Case Officer: Andrew Lewis

Applicant: Heyford Park Commercial Developments Limited

Proposal: Discharge of condition 42 (fire hydrants) of 10/01642/OUT – Village Centre North only

SUB-CASE/DRAWING No: 50179486
DRAWING REVISION: 4

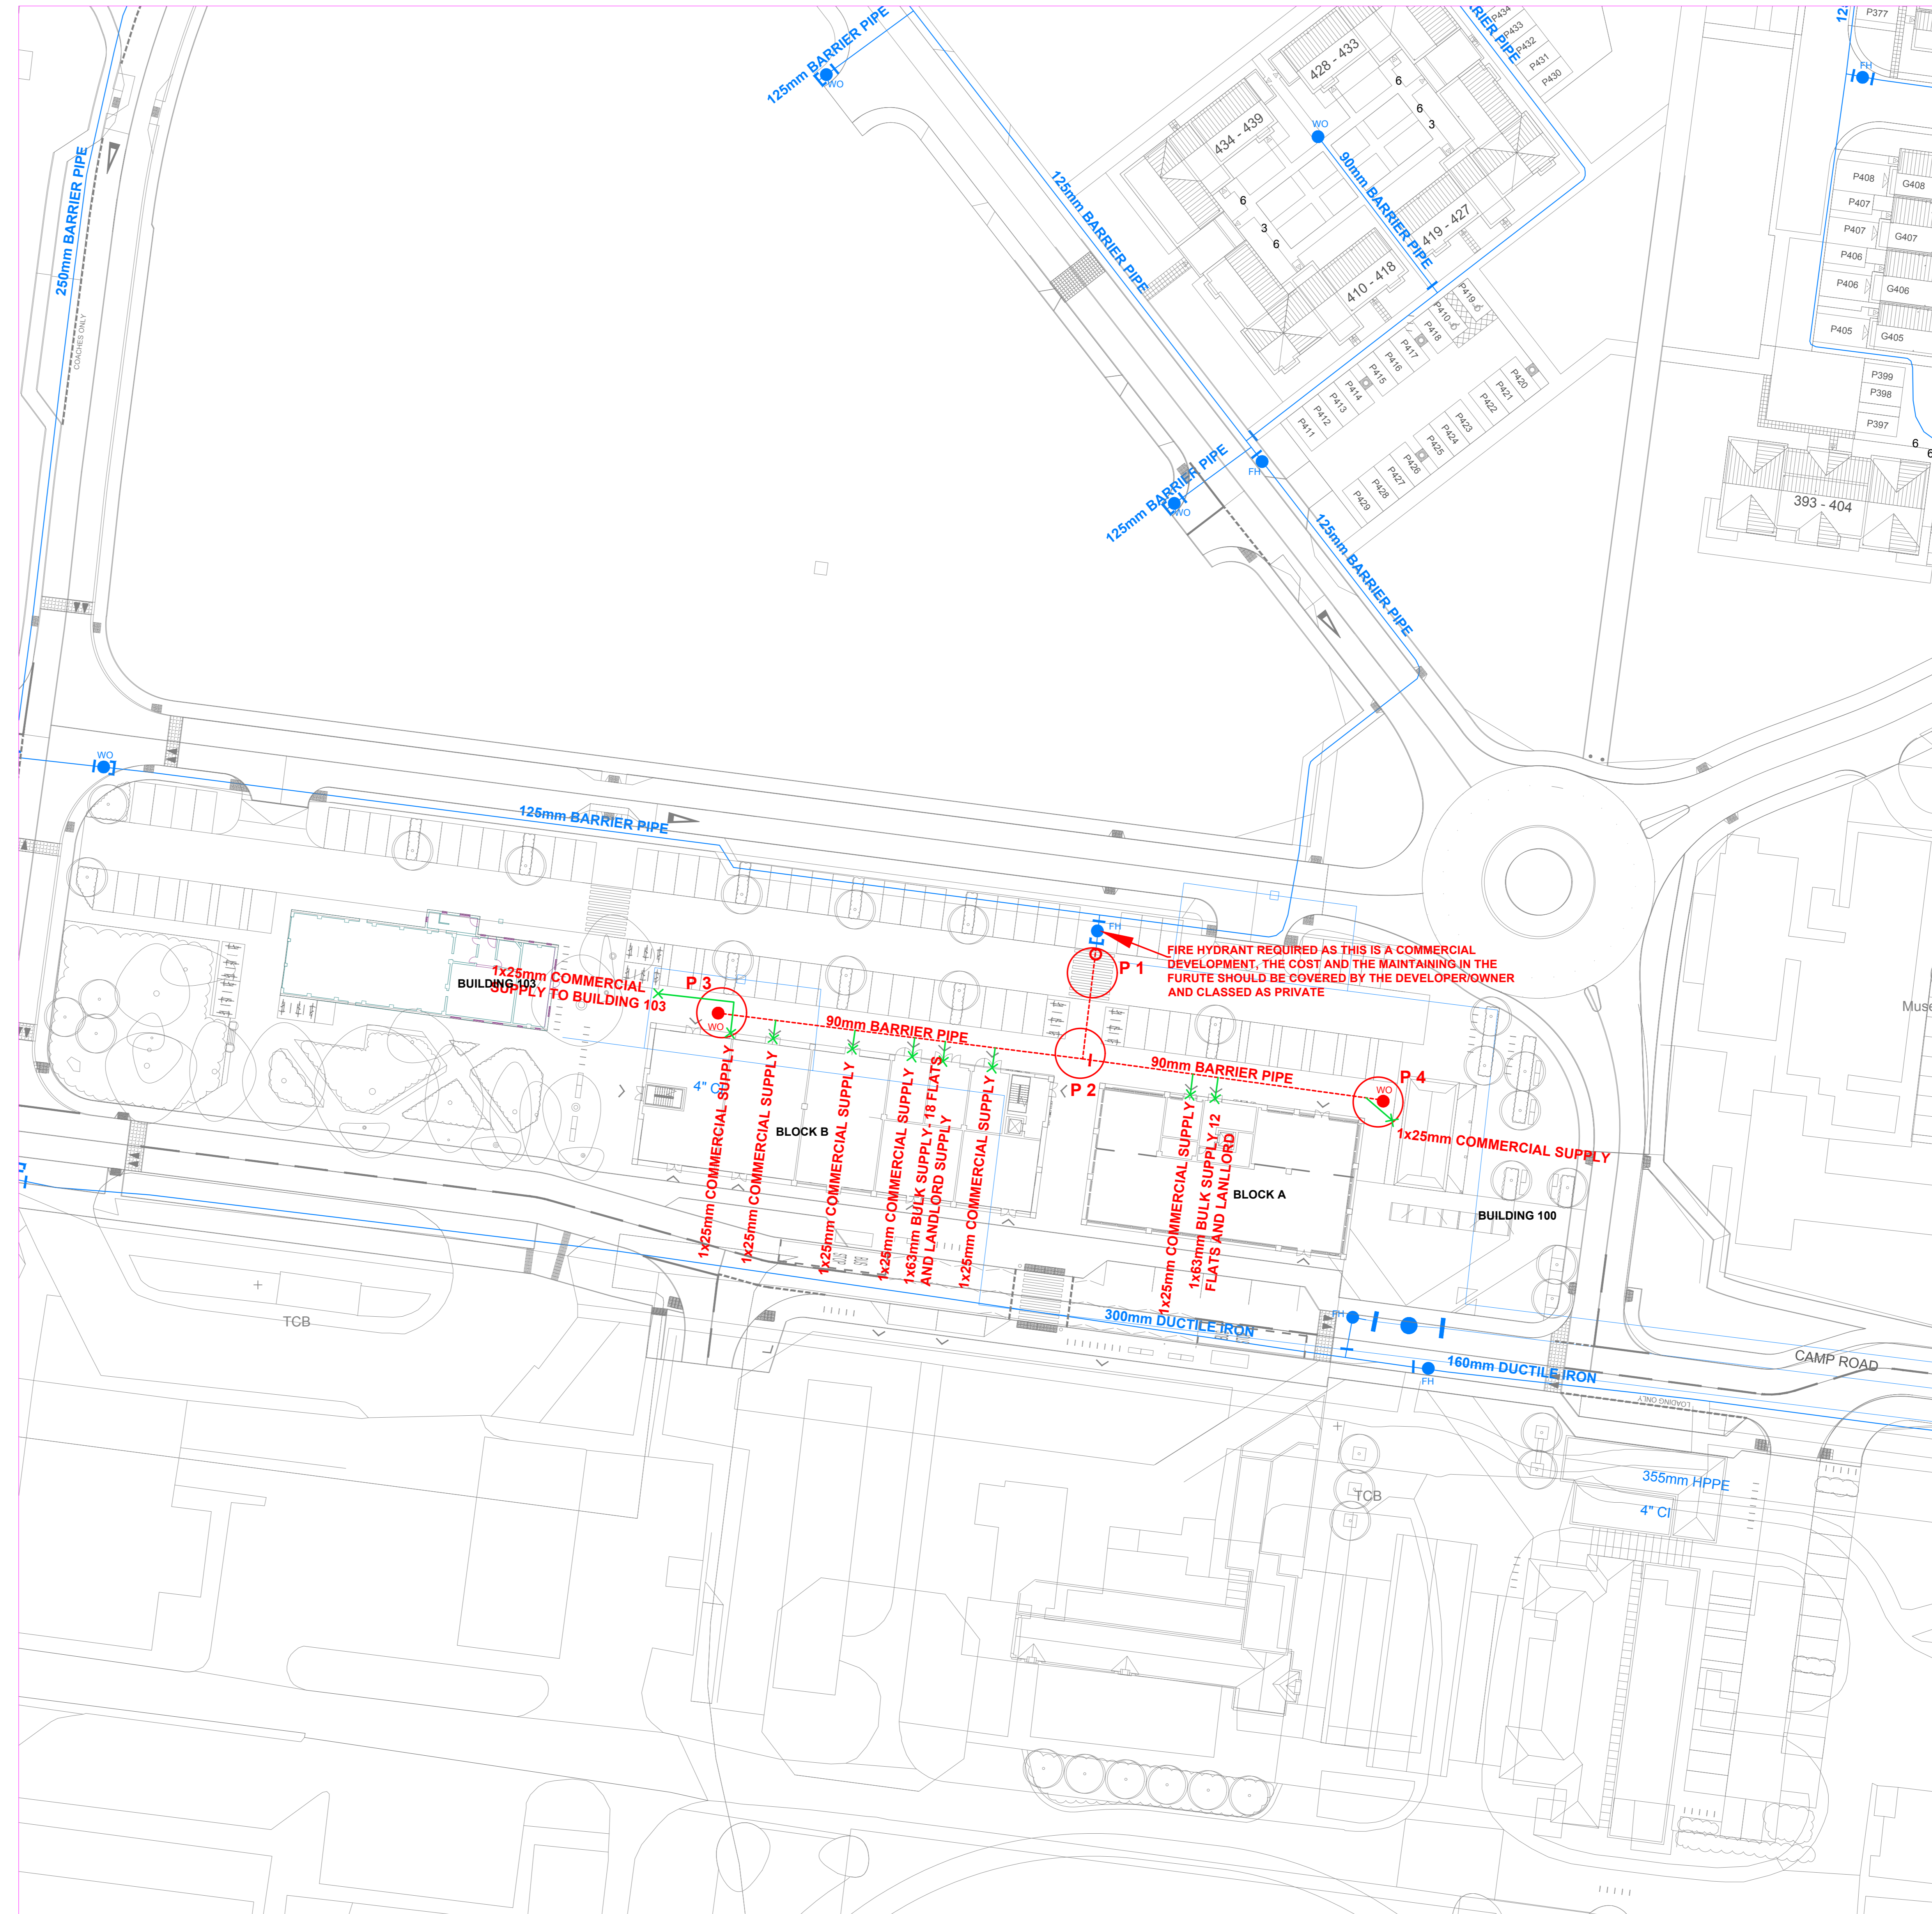
- 4.1. CDC CONSERVATION: **Comments** if the fire hydrants are standard modern issue that are required for operational reasons – there is no need for the Conservation Team to be consulted.
- 4.2. OXFORDSHIRE COUNTY COUNCIL - Fire & Rescue Service: Subject to the hydrant being provided as per plans submitted, we are satisfied with the provision.

- 5.1. The position of the 4 hydrants is shown on the submitted drawing. They appear accessible but at the same time discretely positioned. Clearly, they are a necessity for a development of this type and scale.
- 5.2. Neither the Fire Officer nor Conservation Officer raise objections therefore it is recommended this condition be discharged.

Approval is given for the position of the fire hydrants as shown on drawing No. 50179486 Rev 4
